Application no: 23/03073/HYBRID

Location: Phase 2 SW Bicester Kingsmere Parcel R East Of, Ludlow Road, Bicester

Transport Schedule

Recommendation: Objection (further information required)

Insert 3.1 Proposed Pedestrian Connection

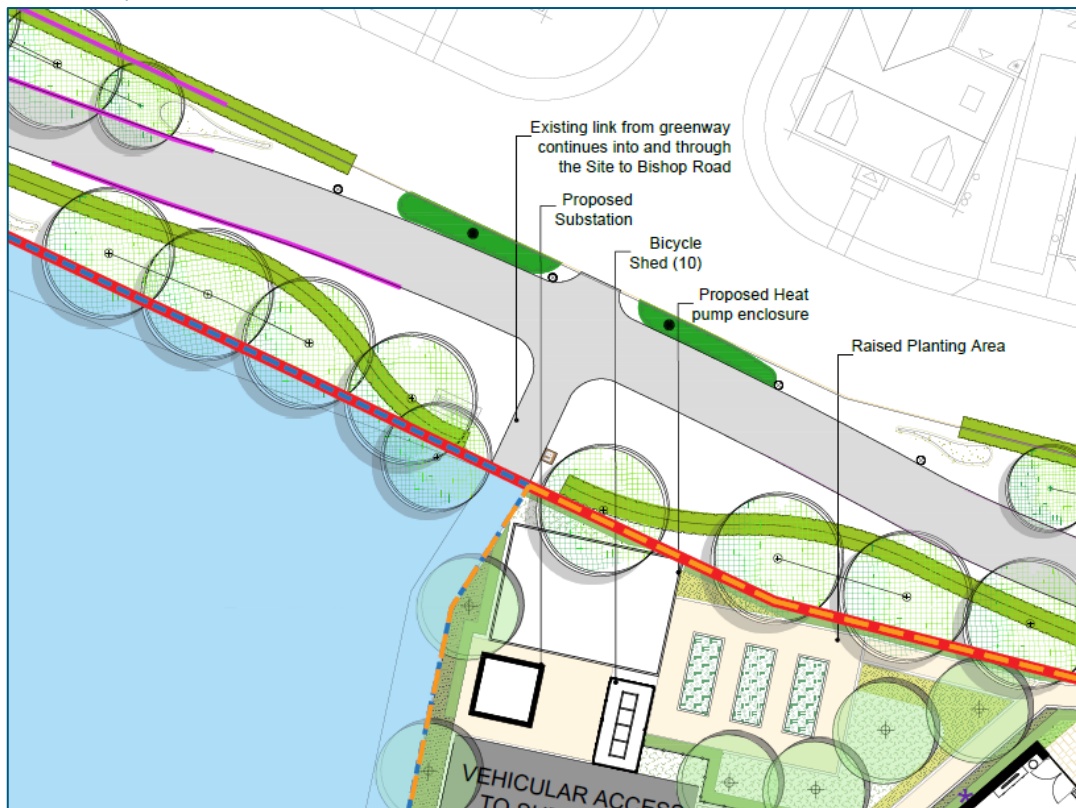
A pedestrian / cycle link to the northwest of the site (near the turning head / substation), connecting to the residential access should be provided / suitably conditioned.
